DORAN DRIVE PRECINCT SHOWGROUND

RESPONSE TO STATE DESIGN REVIEW PANEL - MEETING 3

DEICORP PROJECTS (SHOWGROUND) PTY LTD

Please find below a summary of detailed response prepared by the project team to address the items raised in the letter dated 19th November 2021 by State Design Review Panel. State Design Review Panel meeting was held on 10th November 2021.

# GROUND LEVEL PLAN - DORAN PLAZA WITH MARKET OVERLAY

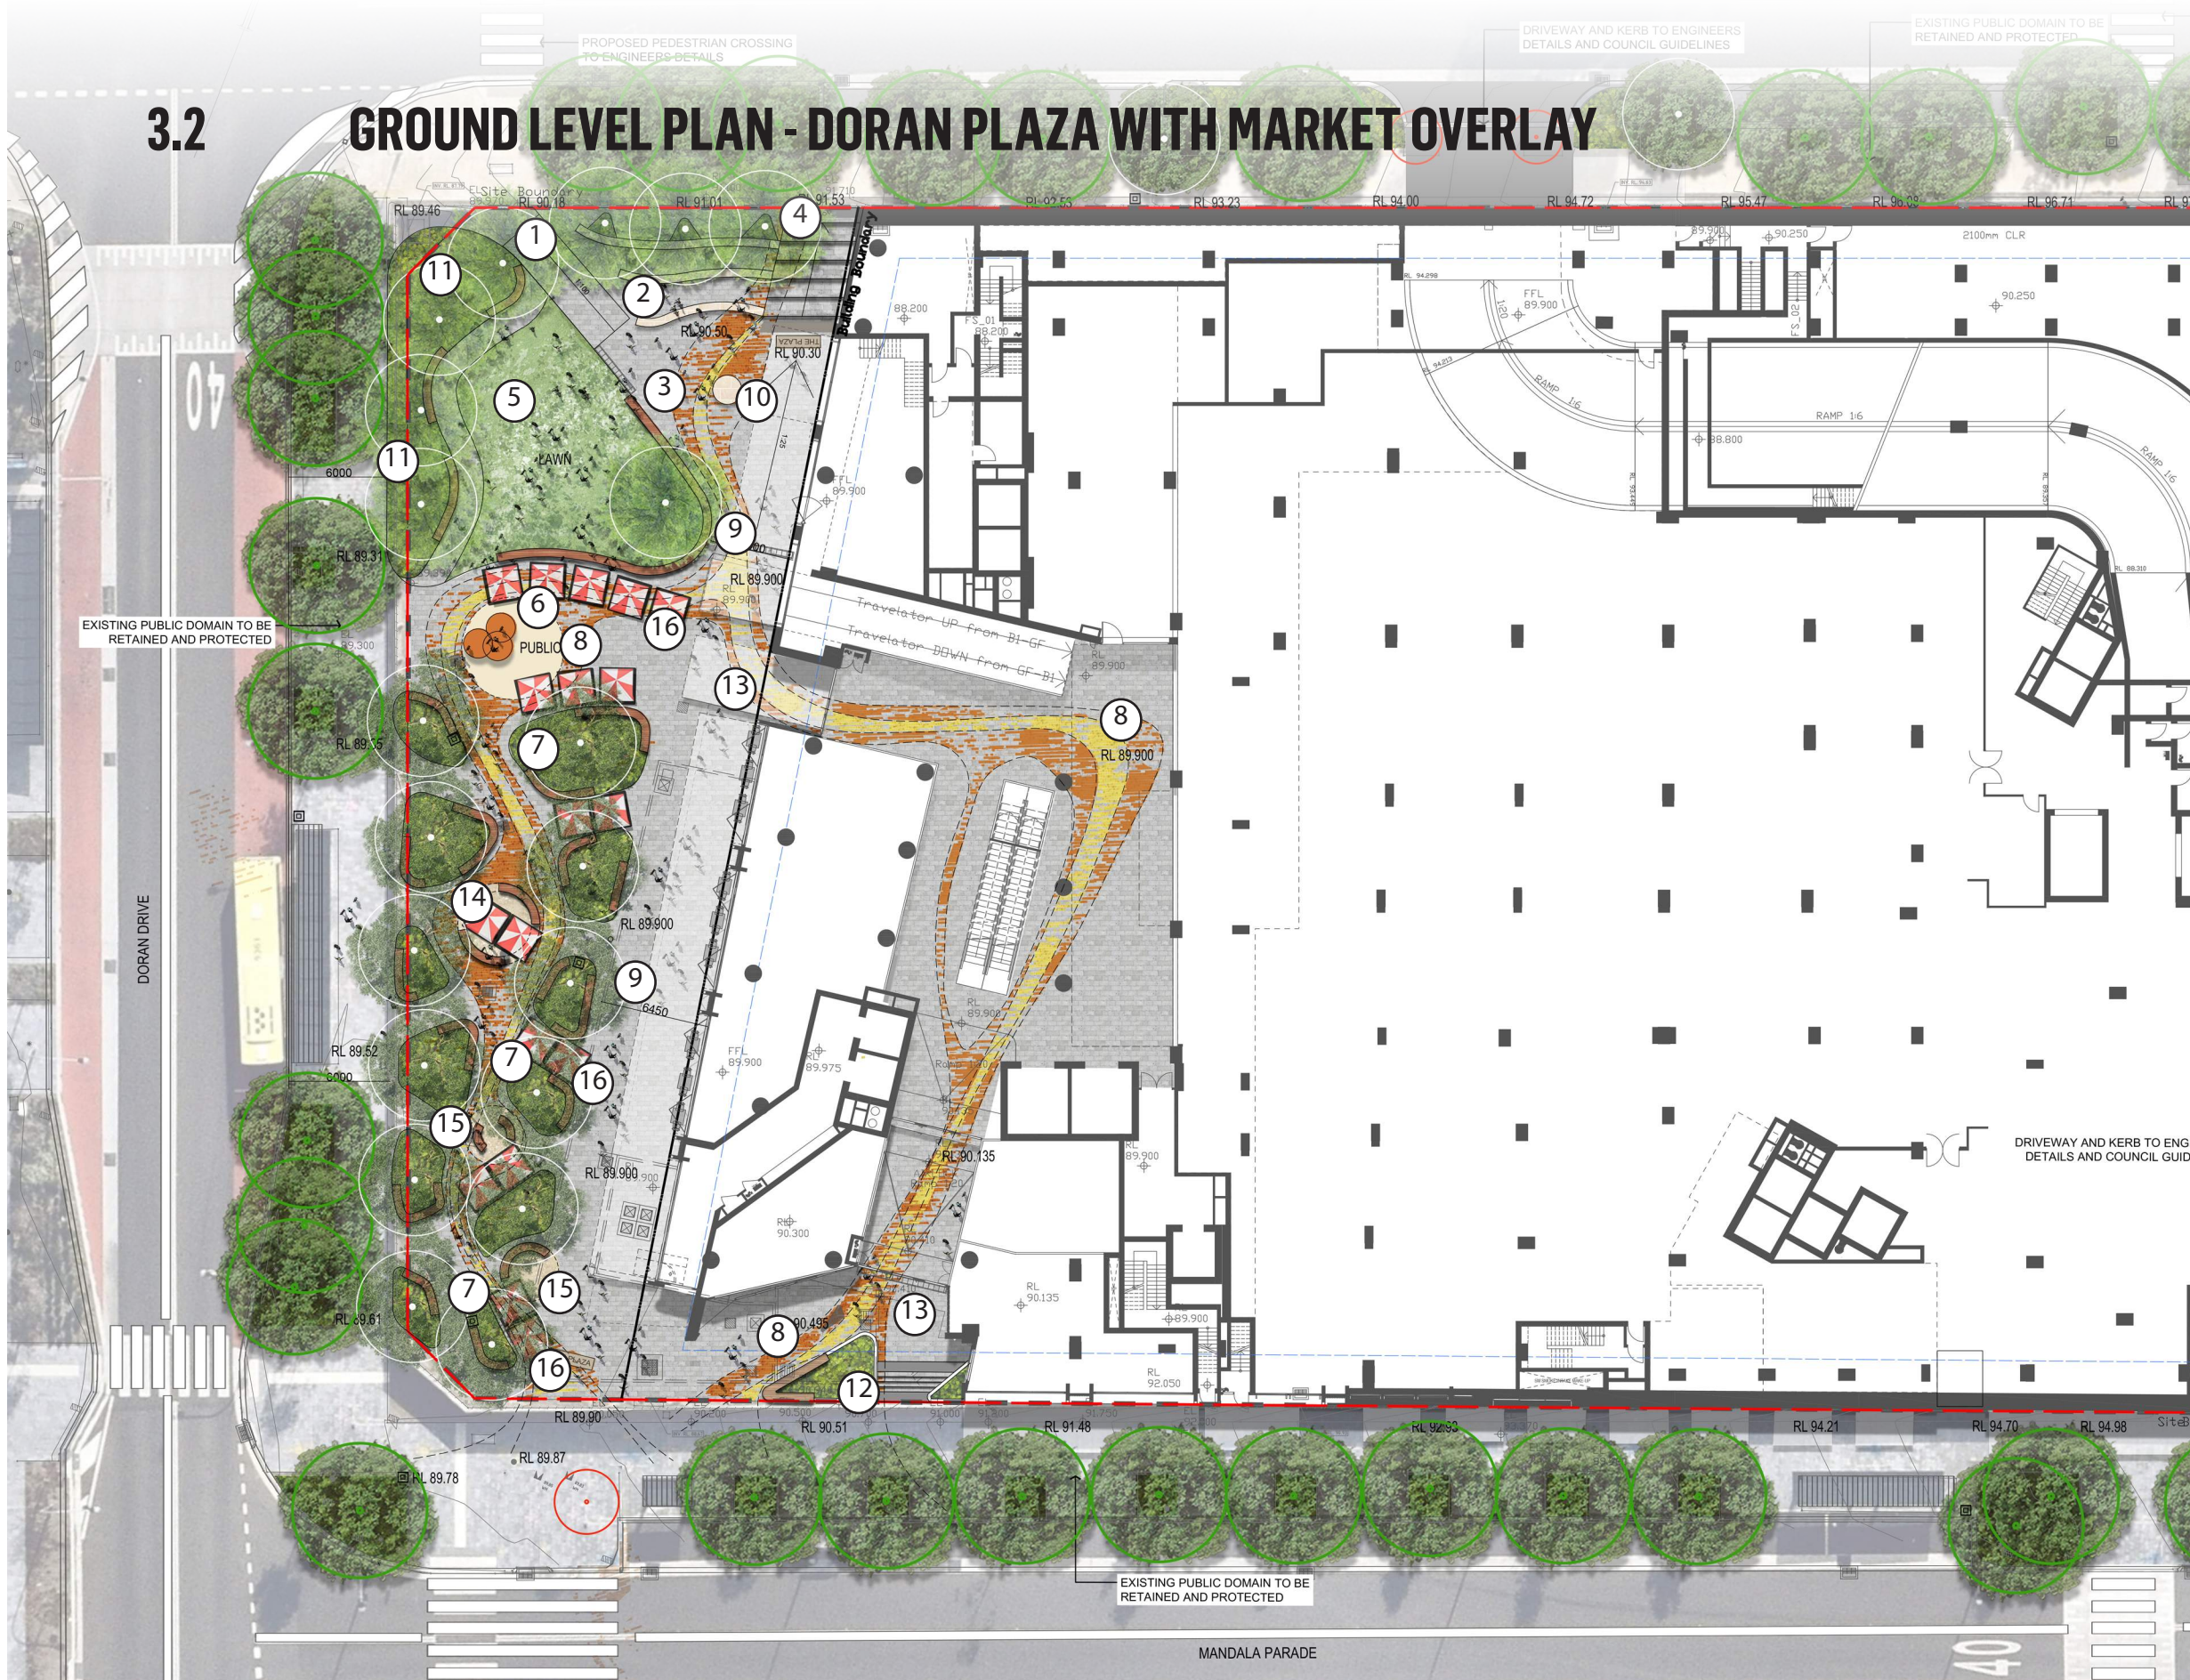
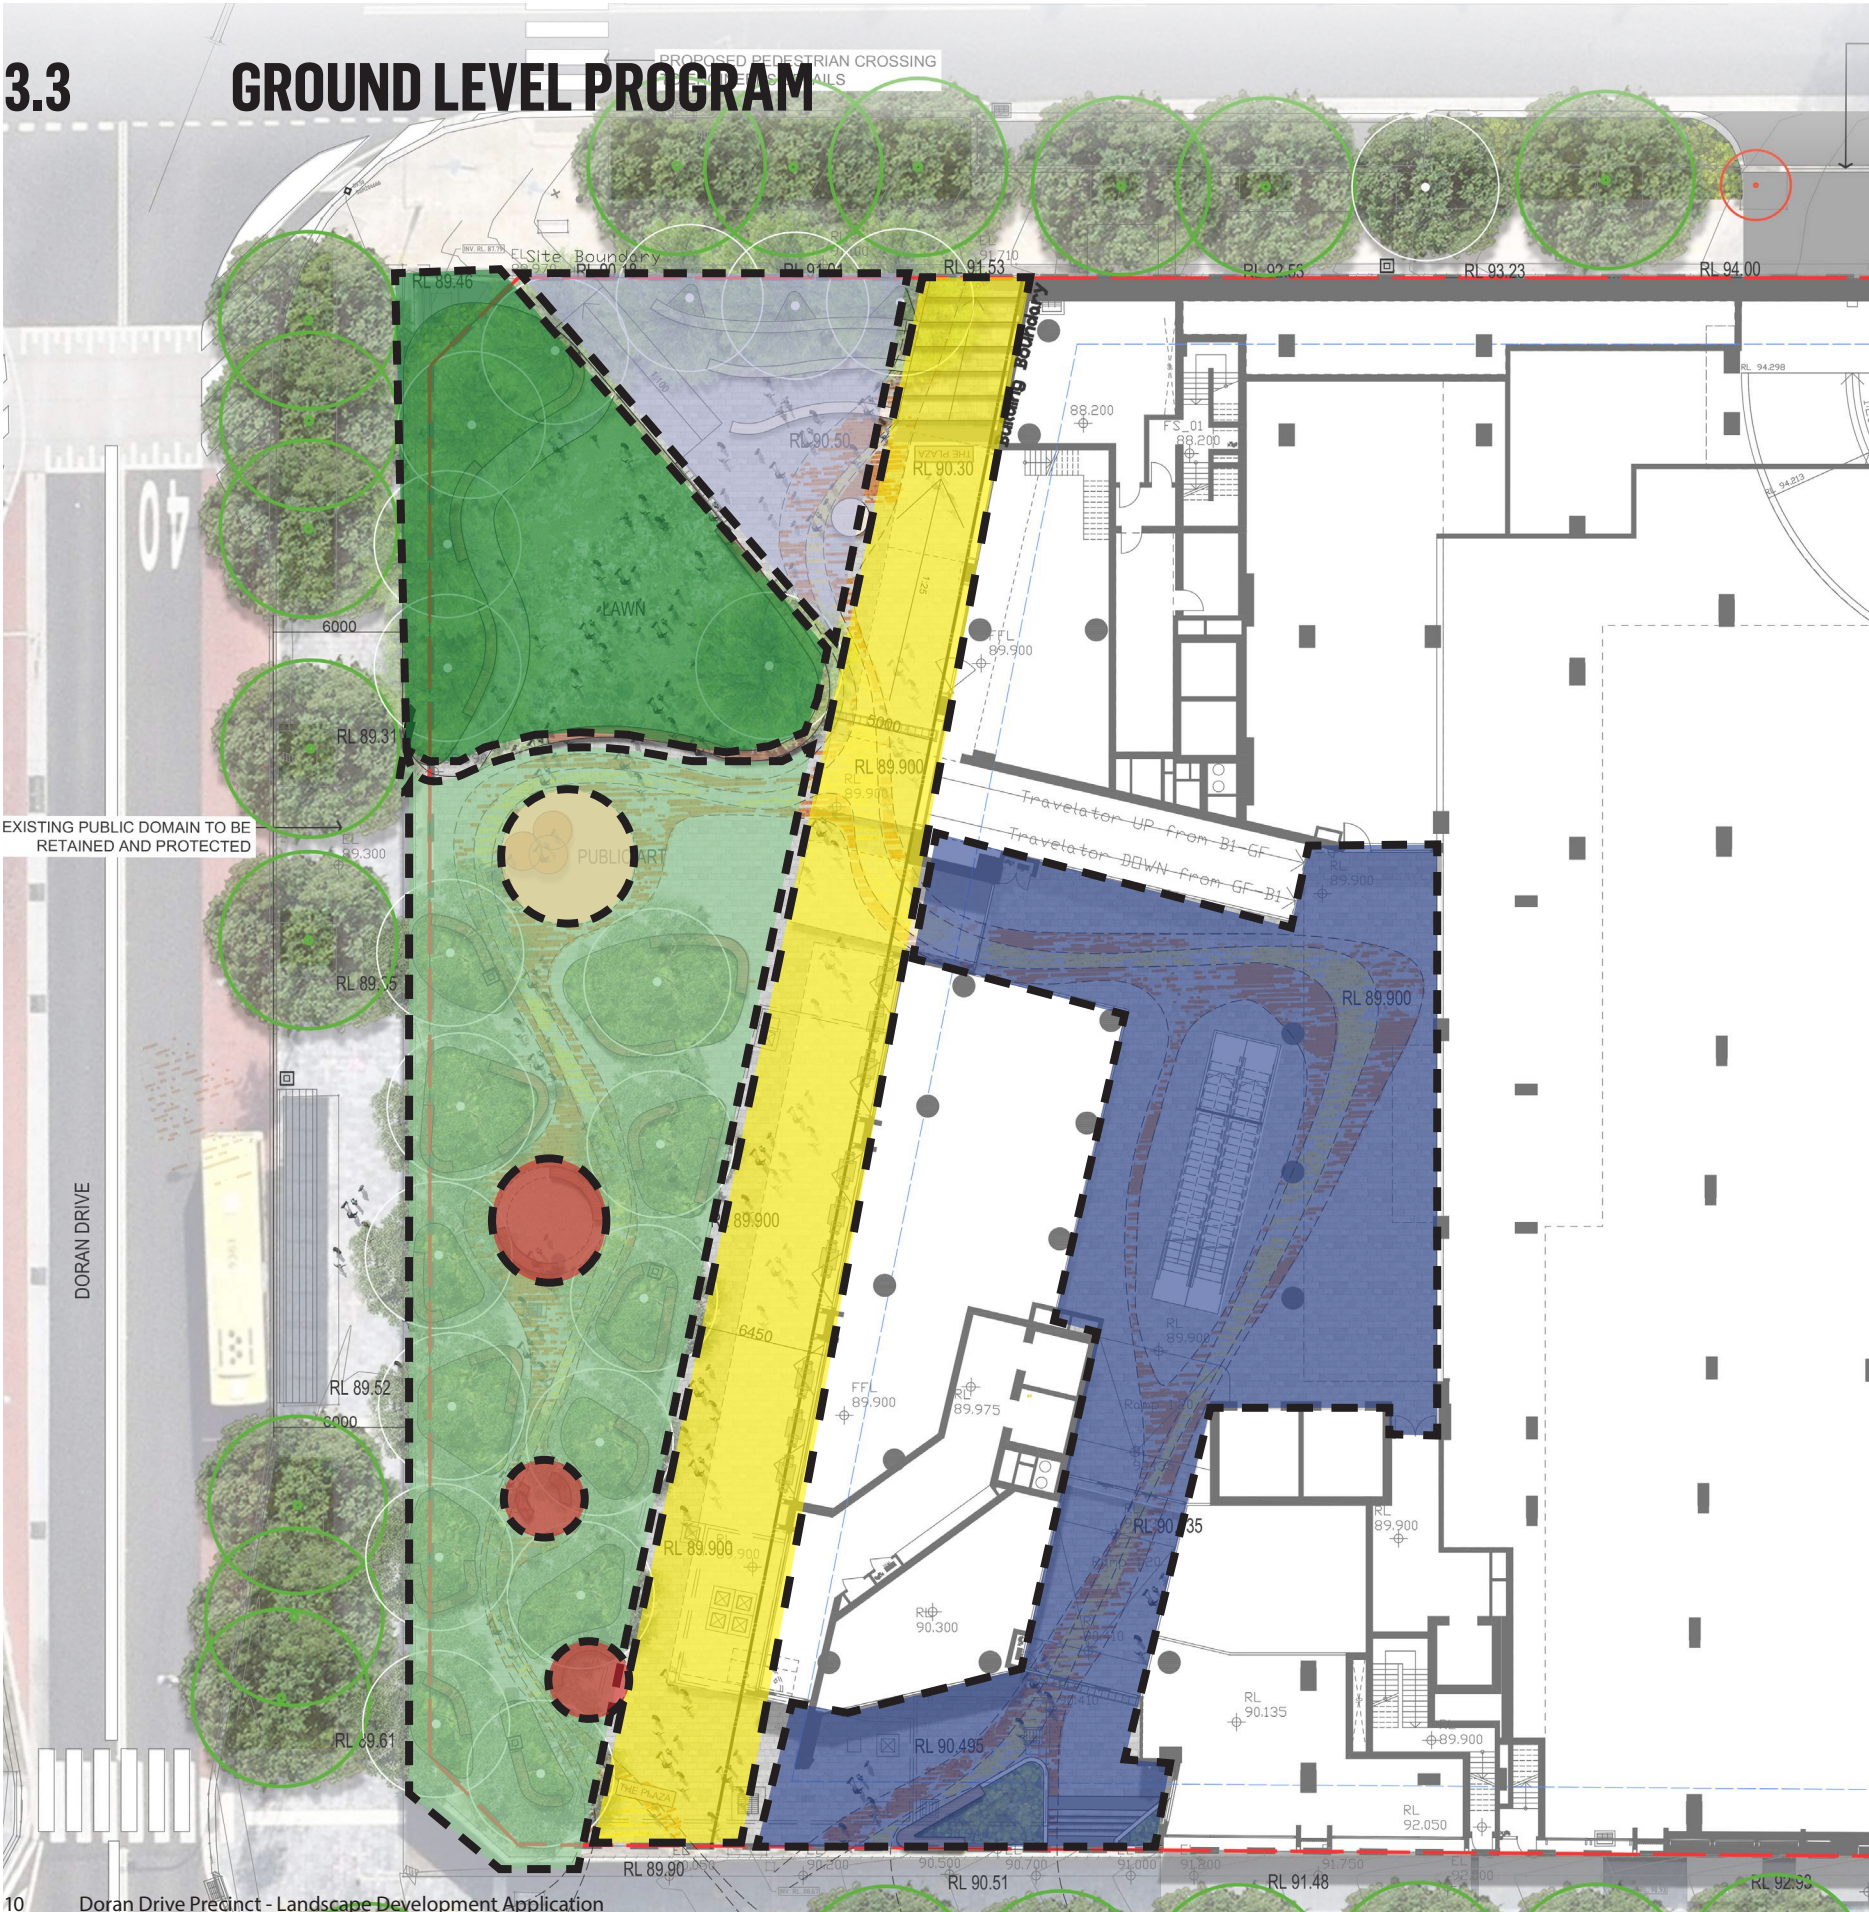
<ul style="list-style-type: none"> • Illustrate the types and quality of landscape spaces, planting, seating and intended activities. 	<p>Urbis Mark Kuhne Director / Registered Landscape Architect #1226 (AILA)</p>	<p>Doran Drive Plaza forms a key piece of open space between the Metro Station and the Castle Hill Showground. The 1,400m² plaza space is bounded by Doran Drive to the west, De Clambe Drive to the north, Mandala Parade to the south and built form to the east.</p> <p>The Plaza is intended to be a high quality, flexible urban open space that functions both as a permeable connection between the station, buses, retail and the Castle Hill Showground, as well as providing an activated and comfortable space for people to use and inhabit day to day.</p>  <p>3D view illustrates the intended activities, planting, materiality and seating</p> <p>Refer to item 1 response for further illustration on all proposed landscaping spaces including Doran Drive Plaza and communal open spaces.</p> <p><u>SITE WIDE PLANTING STRATEGY</u></p> <p>The site wide plant strategy has been inspired by the adjacent Fred Caterson Reserve and bushland types and communities.</p>  <p>Reference – 'The bushland of Fred Caterson Reserve' Baulkham Hills Shire Council 2007</p>

Feature trees to the Doran Drive Plaza include

Tristania laurina, Water Gums – Native Australian Evergreen Tree

Corymbia ficifolia, Red Flowering Gum – Native Australian tree species to attract local birds

Eucalyptus cattai – Critically Endangered Local Eucalypt

# 3.11 LEVEL 6 PLAN

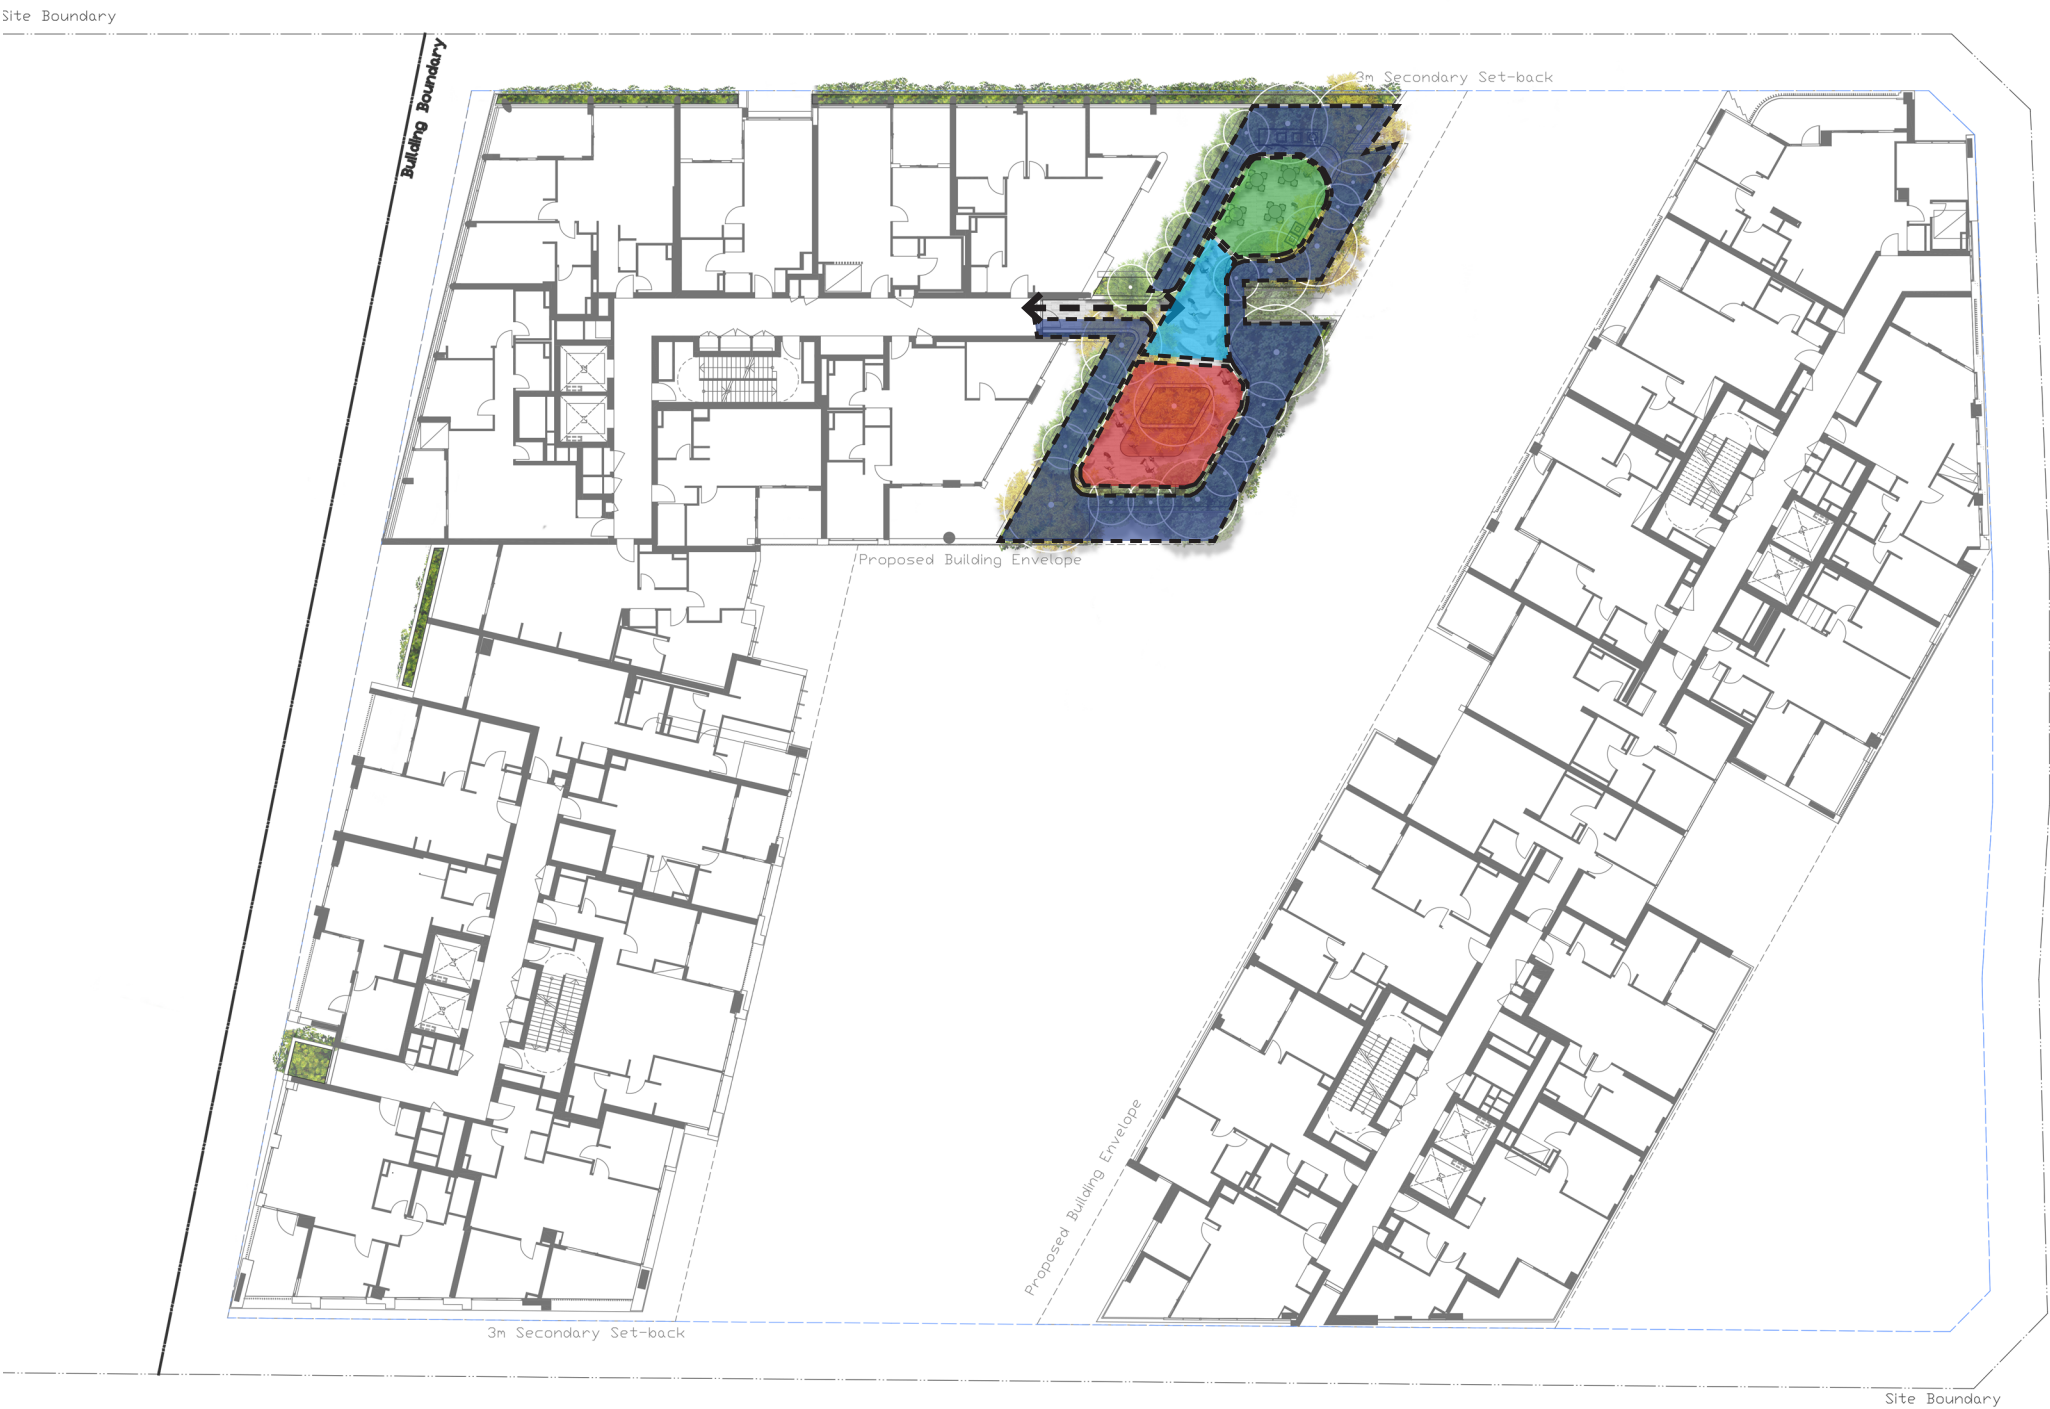
Podium Communal Open Space		
• Provide solar studies	Turner	Minimum 2 hours solar access is achieved to 50% of the primary usable spaces on June 21 st . The primary usable spaces are

demonstrating the required solar access can be achieved for the communal open space above the podium.

located appropriately on the podium and at the large level 6 roof terrace to capture views and outlook. The edges of the podium have been designed as a series of generously planted buffer zones that offer significant privacy to the adjacent private terraces and offer a lush verdant green backdrop of the centrally located primary usable space.
